Subdivision PH Comments

From: Holly Myers, Environmental Health Supervisor

RE: SP-07-00007 Wenger

K.C.S.P. NO. 07-XX
Ptn. of the NE1/4 of Sec. 29, T.20N., R.14E., W.M.
Kittitas County, Washington

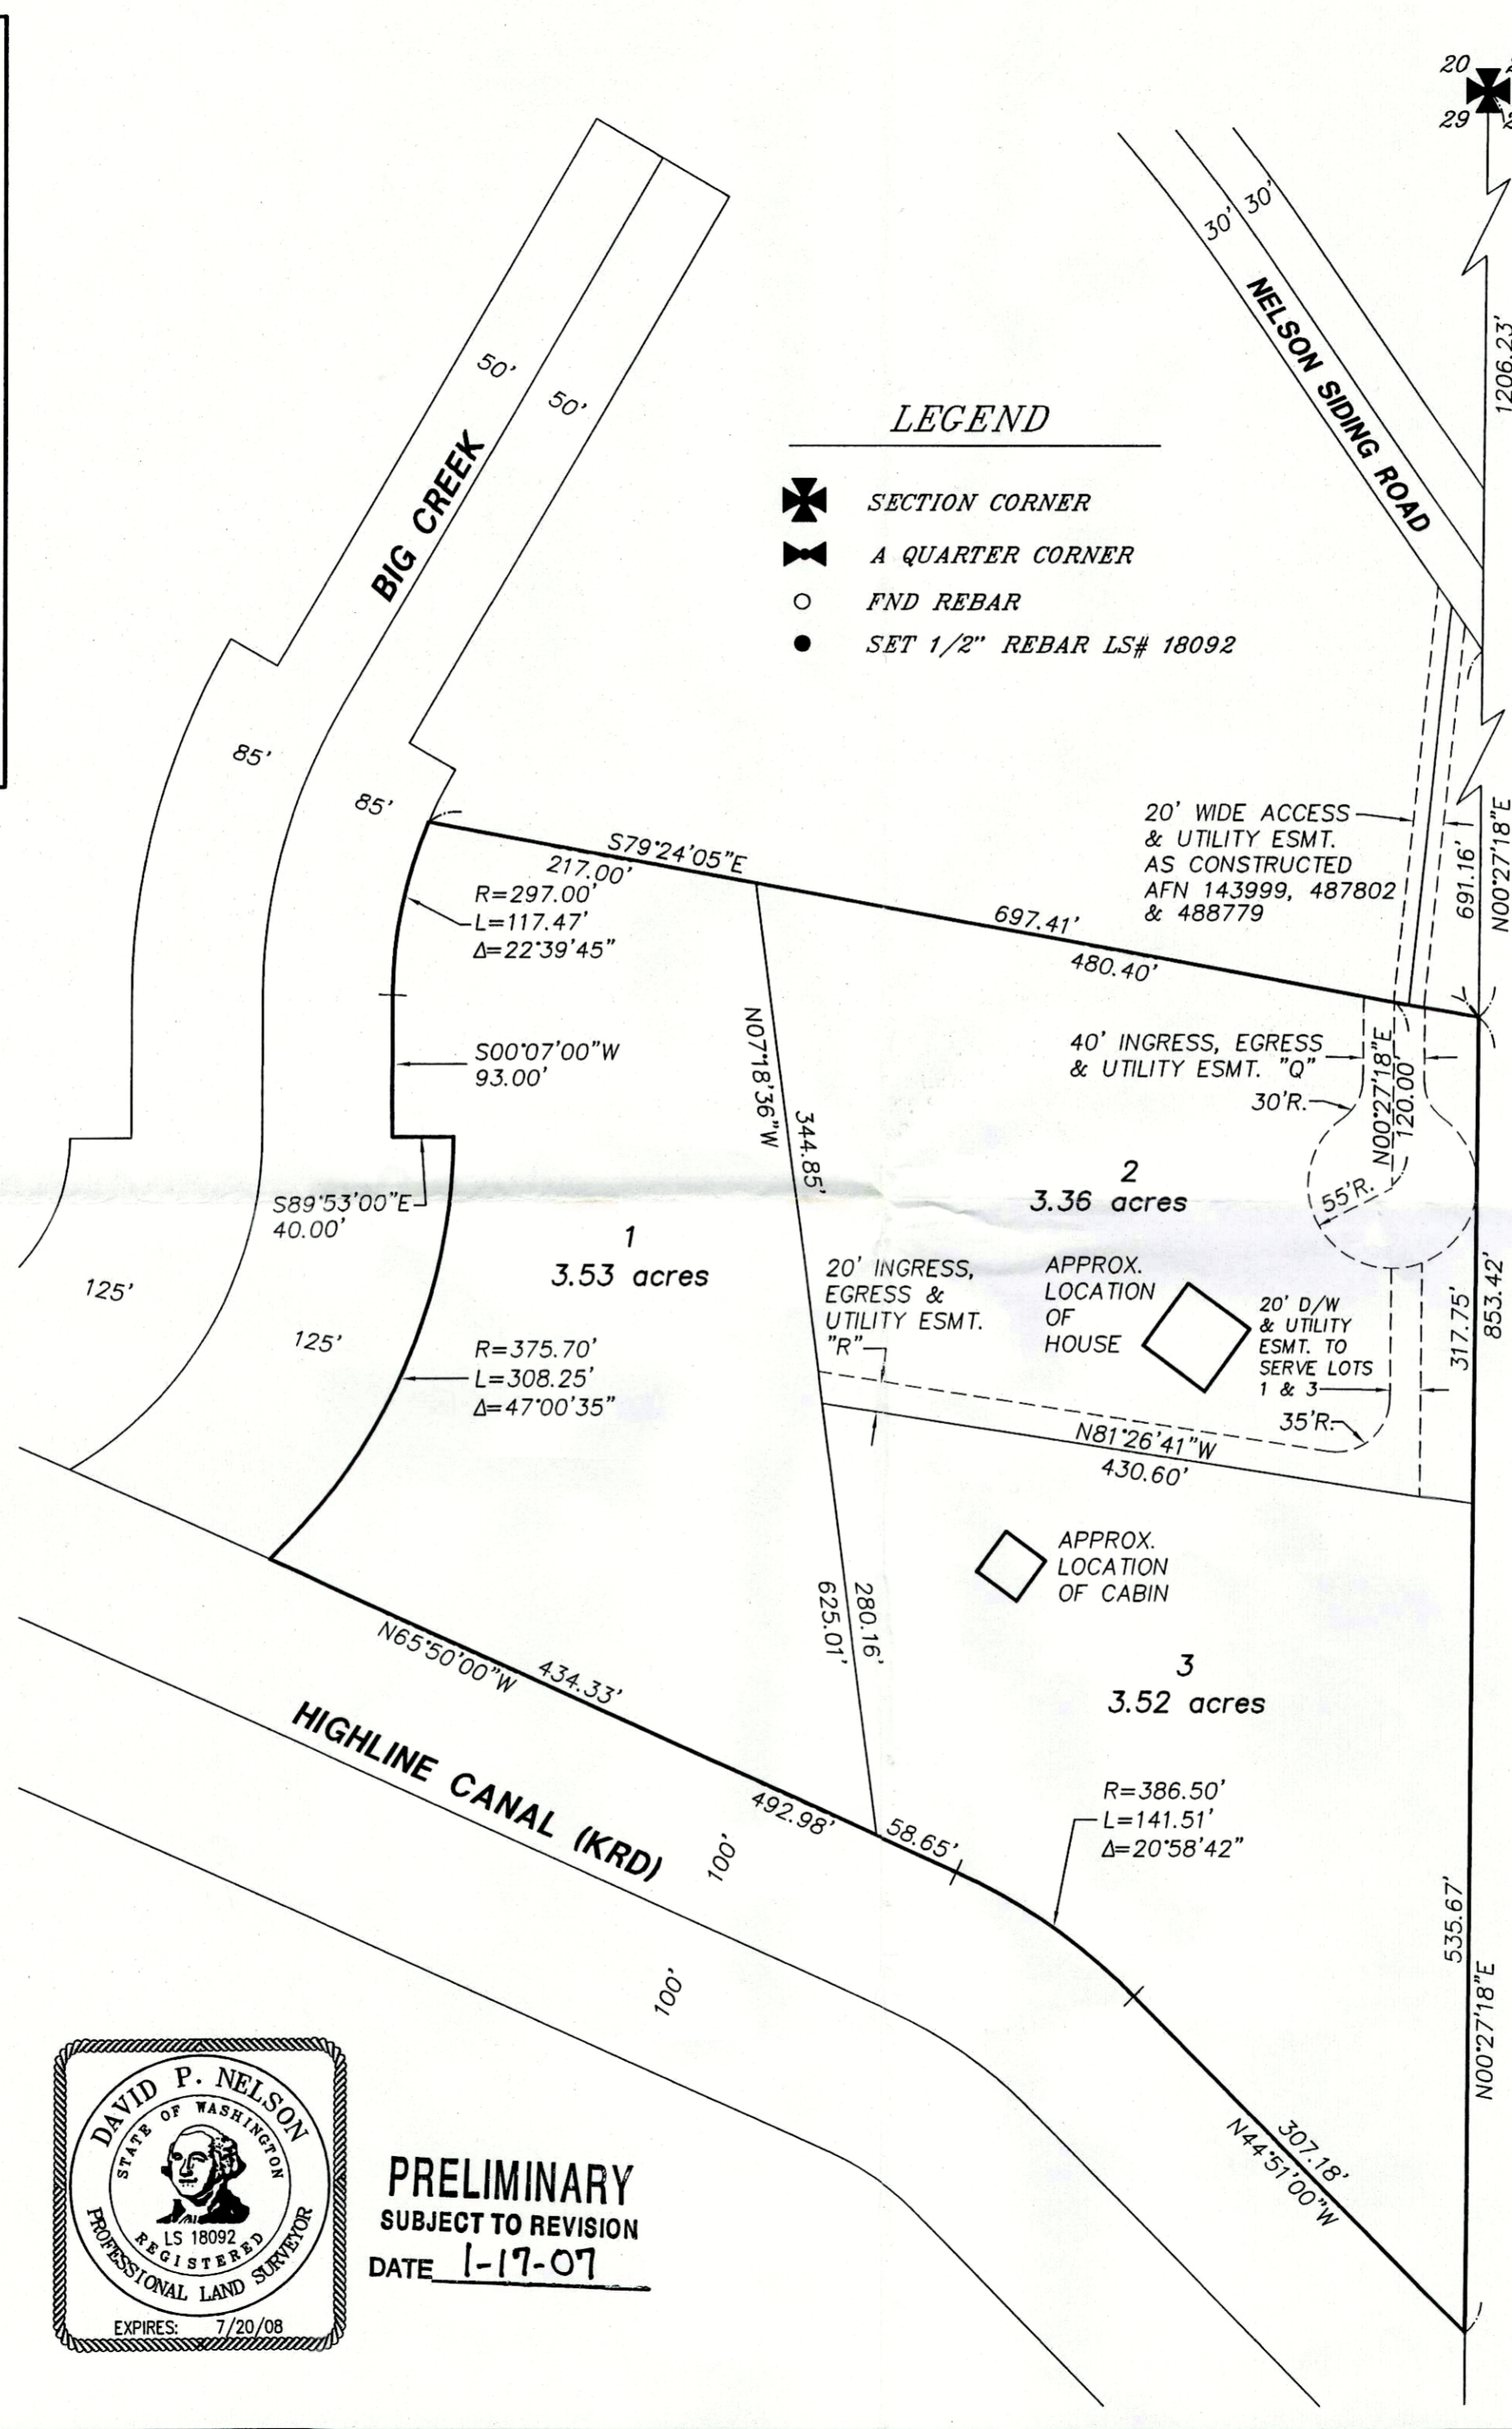
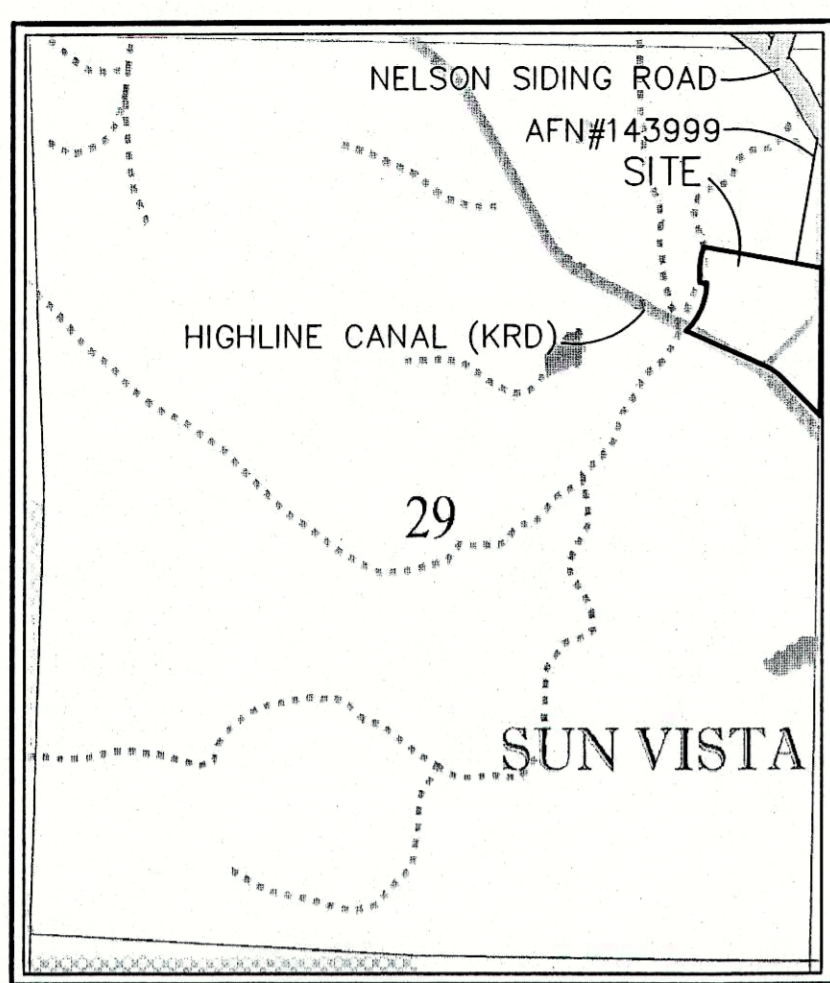
- Proof of adequate water supply and availability of groundwater for the proposed well currently in use. If the well between lot 2 and 3 will be shared between the lots, a shared well users agreement must be signed, and recorded for both related parcels with the auditor's office.
- Proof of water adequacy includes a well log or 4 hour draw down test.
- Lot 3 has no well or structure; therefore applicant must provide proof of mitigation of adequate water prior to final plat approval per KCC Chapter 13.
- Soil logs must be completed on lots without an existing septic system.
- Site evaluations for Onsite Septic Systems must be completed at the frequency of one soil log per lot. (KCC 13.04.090 (1(f))).

16. Well location. The drawings shall be marked with a "w" indicating location of the well and a broken line showing the one hundred foot radius around such.

All wells must meet the distance requirement of 50 feet from the property line, 50 feet from the septic tank and 100 feet from the drain field as per Kittitas County Critical Areas Ordinance 17A.08.25, and KCC Chapter 13. If existing wells do not meet the setback requirement from property lines, the two adjoining parcels nearest the well must enter into a legal, shared well-users agreement.

16.12.020 Unless otherwise specified, information required below may be placed on either sheet one or subsequent sheets or on all sheets as necessary. (9) A statement regarding the contemplated sewage disposal, potable water supply, and drainage improvements for the proposed subdivision.
